Rezoning Transportation Analysis

Petition Number: 2020-018

General Location Identifier: Tax ID 14501314

Date	Description
03-19-20	First Review

**RZ-1**

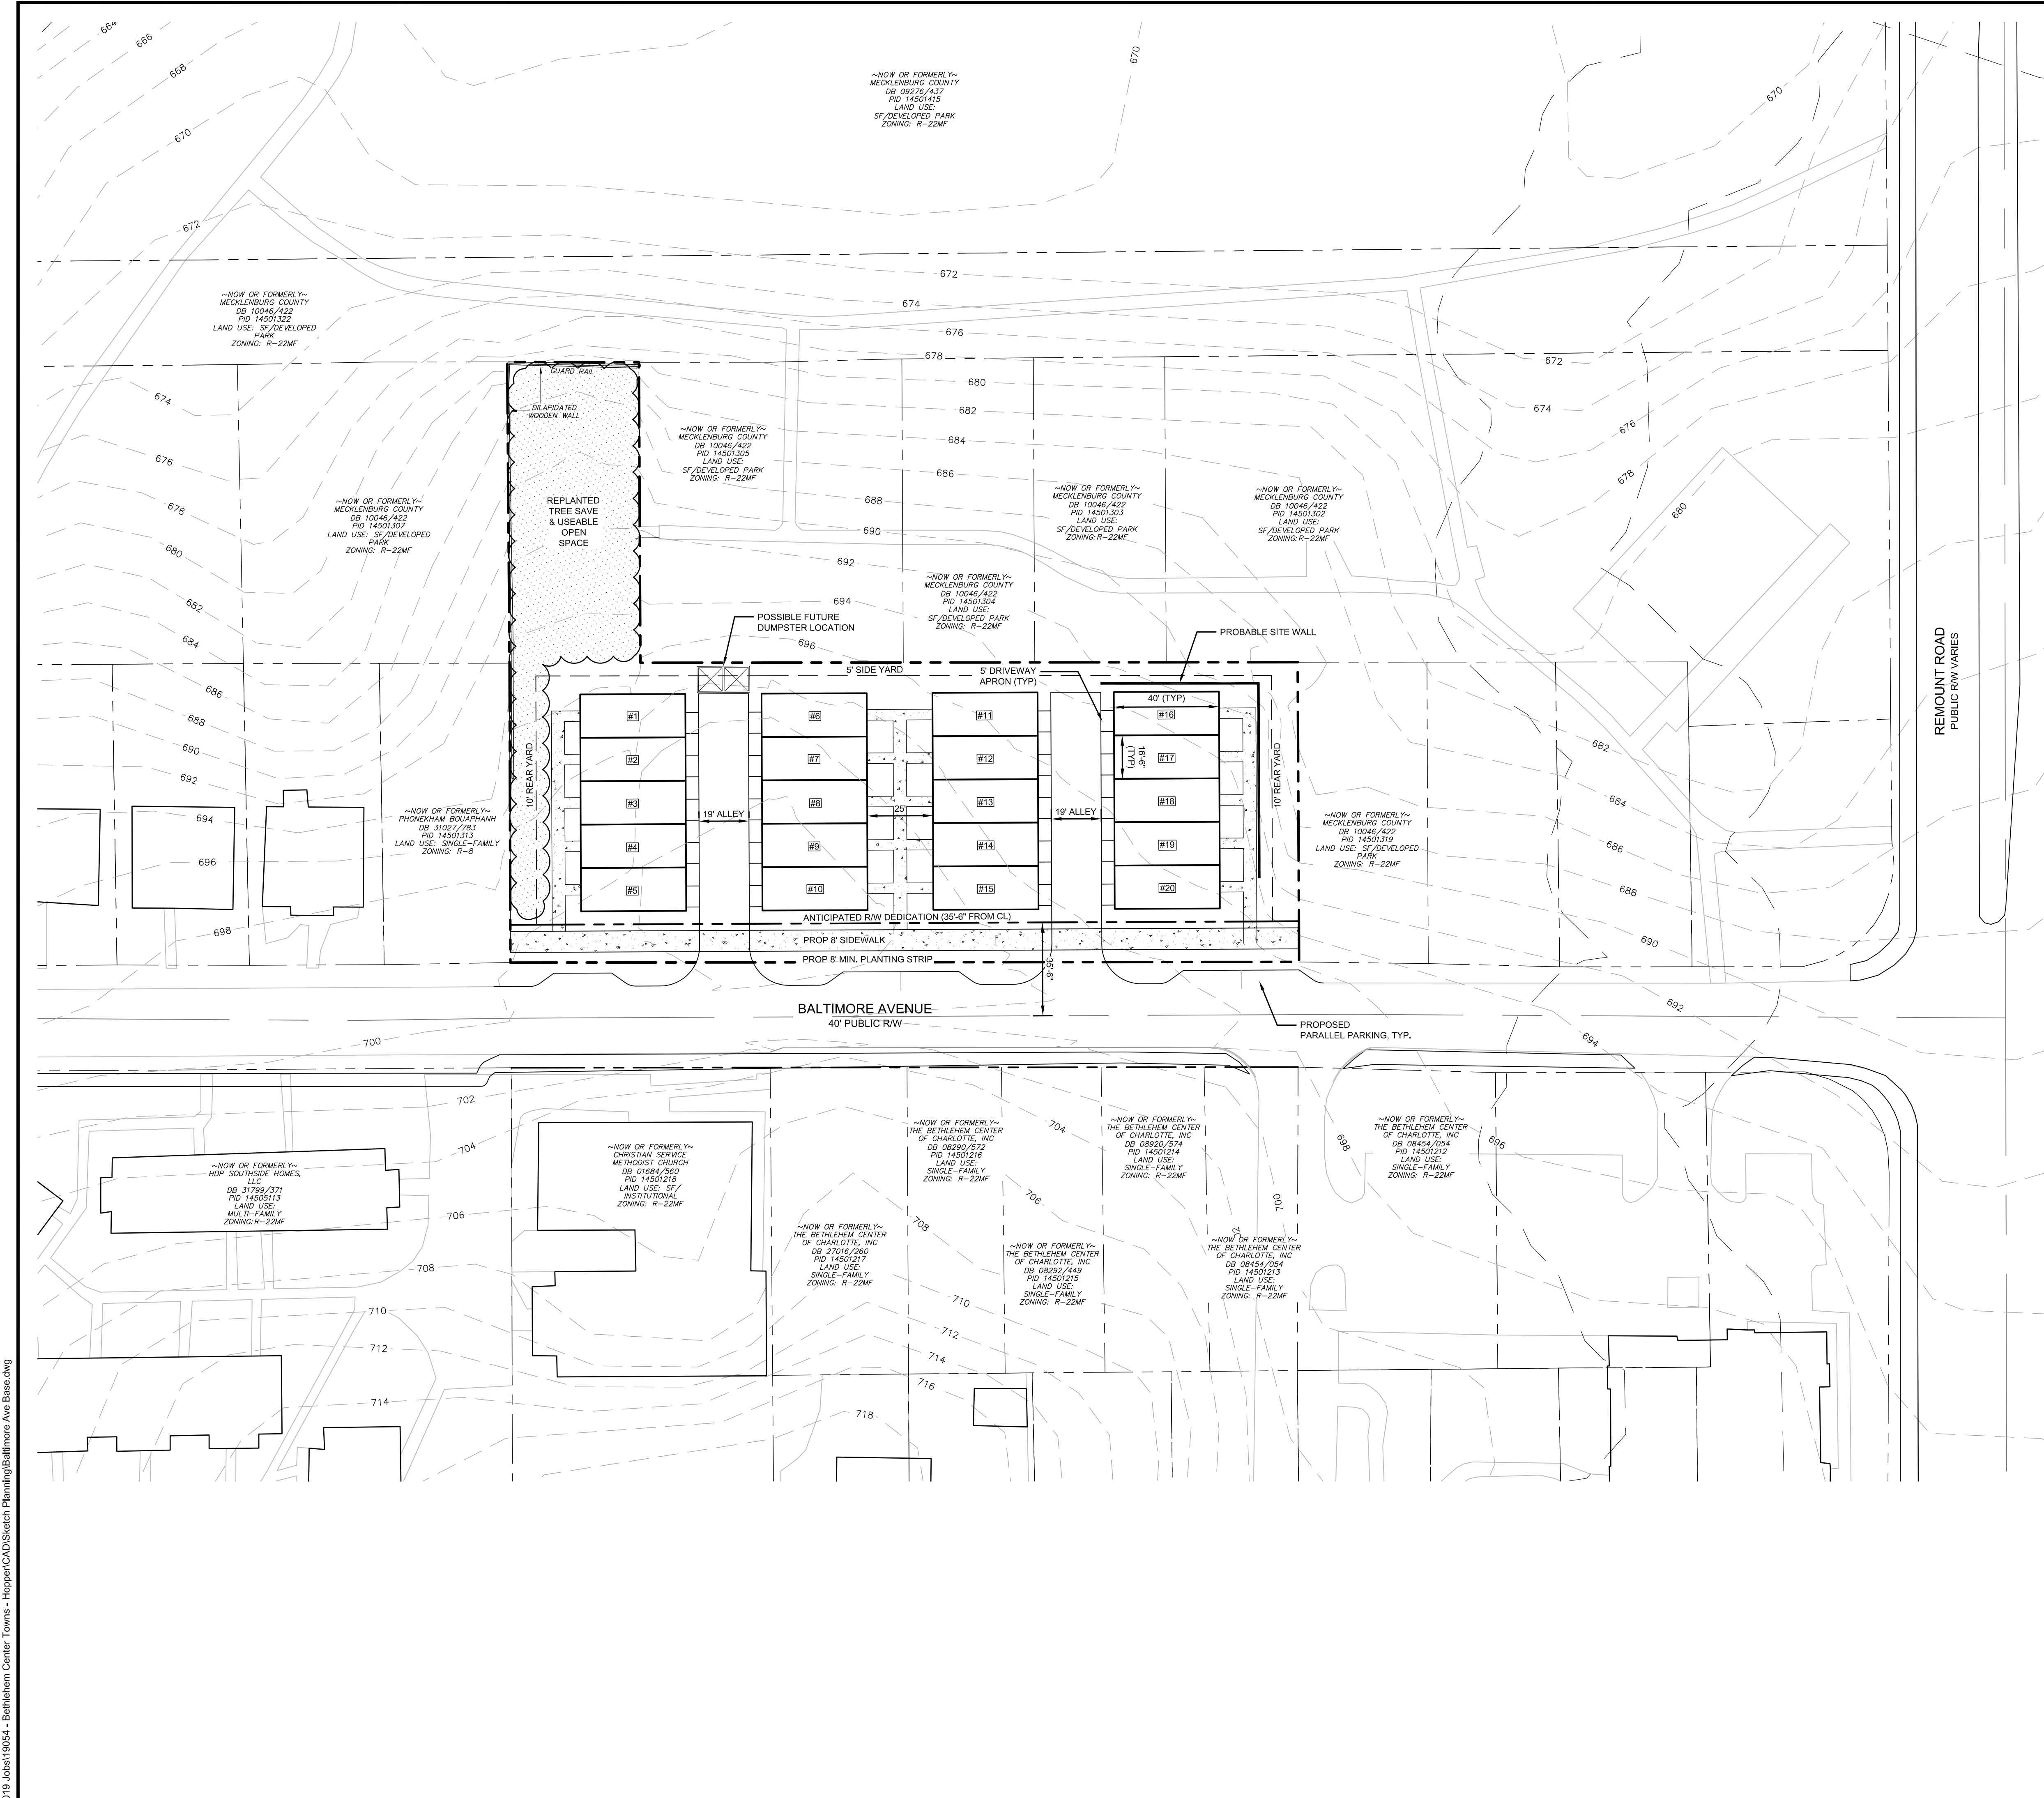
- 1. Curbline** The proposed zoning district has a setback measured from back of the existing or proposed future curbline.

- a. Baltimore Avenue:** The proposed location of curb and gutter should be revised to 17.5 feet from existing road centerline, per the Urban Street Design Guidelines (USDG) Charlotte Land Development Standards Manual (CLDSM) standard detail U-03A – Local Residential Wide Street Typical Section and Chapter 19 of the Charlotte City Code. Curb and gutter should be constructed with on-street parking.

The site plan should show the curb and gutter labeled and dimensioned from the centerline for each road.
- ~~2. **Traffic Study** A Traffic Impact Study is not necessary for the complete review of this petition due to the site generation more than 2500 daily trips. If the during the permitting process the site generates more than 2500 daily trips, then a traffic study will be required.~~

3. We request the petitioner to revise the site plan and conditional note(s) to construct a sidewalk connection to Remount Road with curb and gutter, in reference to the Vision Zero Action Plan and Charlotte WALKS. CDOT has notified Mecklenburg County of the possibility of the petitioner possibly attaining right of way and a construction easement to establish this connection. Please contact Jacqueline McNeil at (Jacqueline.McNeil@mecklenburgcountync.gov) or (+1-980-314-2511) to begin this process. The proposed sidewalk connection will tie-into the proposed improvements requested to rezoning petition 2019-017.

- The petitioner should revise the site plan and conditional note(s) to coordinate with the petitioner of 2020-017 to align one of the two proposed driveways with the proposed access within rezoning petition 2020-017's proposed site plan, or vice versa.

- The petitioner should revise the site plan to clarify conditional note (Section III. Transportation, 4) to specify dedication and fee simple conveyance of all rights of way to the City before the site's first building certificate of occupancy is issued. CDOT requests right of way set at 2' behind back of sidewalk where feasible.

- The petitioner should revise the site plan to clarify conditional note (Section III. Transportation, 5) to specify that all transportation improvements will be approved and constructed before the site's first building certificate of occupancy is issued. The petitioner may phase transportation improvements if said improvements and phasing are explicitly described in site plan notes.

- The petitioner should revise the site plan and conditional note(s) to show turning movements of how trucks will handle waste without maneuvering or reversing into the right of way.
